STAFF REPORT

LAKE SHORE MEADOWS PERFORMANCE BASED CLUSTER PLAT

TO: Kittitas County Hearing Examiner
FROM: Kittitas County Community Development Services Staff
RE: Lake Shore Meadows Performance Based Cluster Plat (P-08-09)
DATE: September 11, 2008

DWN BY	DATE	JOB NO.
T. ROLETT	02/2008	07208
CHKD BY	SCALE	SHEET
D. NELSON	1"=100'	2 OF 4

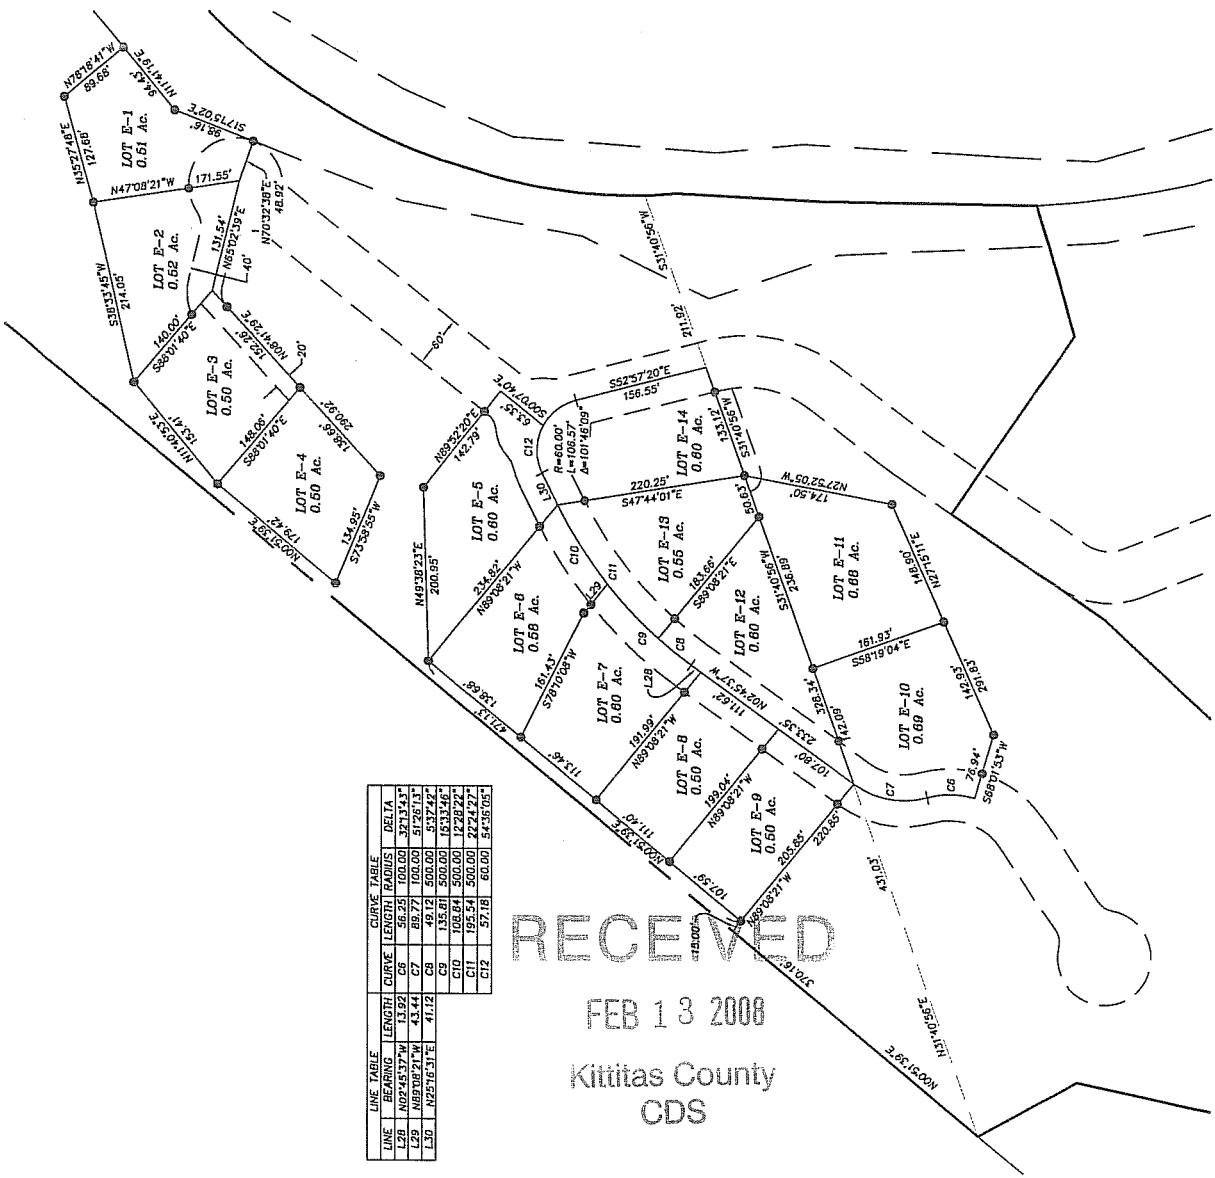
12. The portion of Easement 'Q' that passes through Lot F shall be recorded prior to final approval.
13. The easement serving Lot E-11 shall be described on the plat.

14. Lot E-2 shall be accessed from the cul-de-sac.
15. The 20' and 40' access easements shall be labeled as access for Lots E-3 and E-4 only. The 40' easement may be reduced to a 20' easement as required for a joint-use driveway.

16. Salmon La Sac Road shall be labeled as a 100' easement rather than a 100' R/W.
17. Access from Salmon La Sac to both cul-de-sacs shall be constructed to meet or exceed the conditions of a High-Density Private Road that serves 15-40 tax parcels. See current Kittitas County Road Standards, 9/6/05 edition.
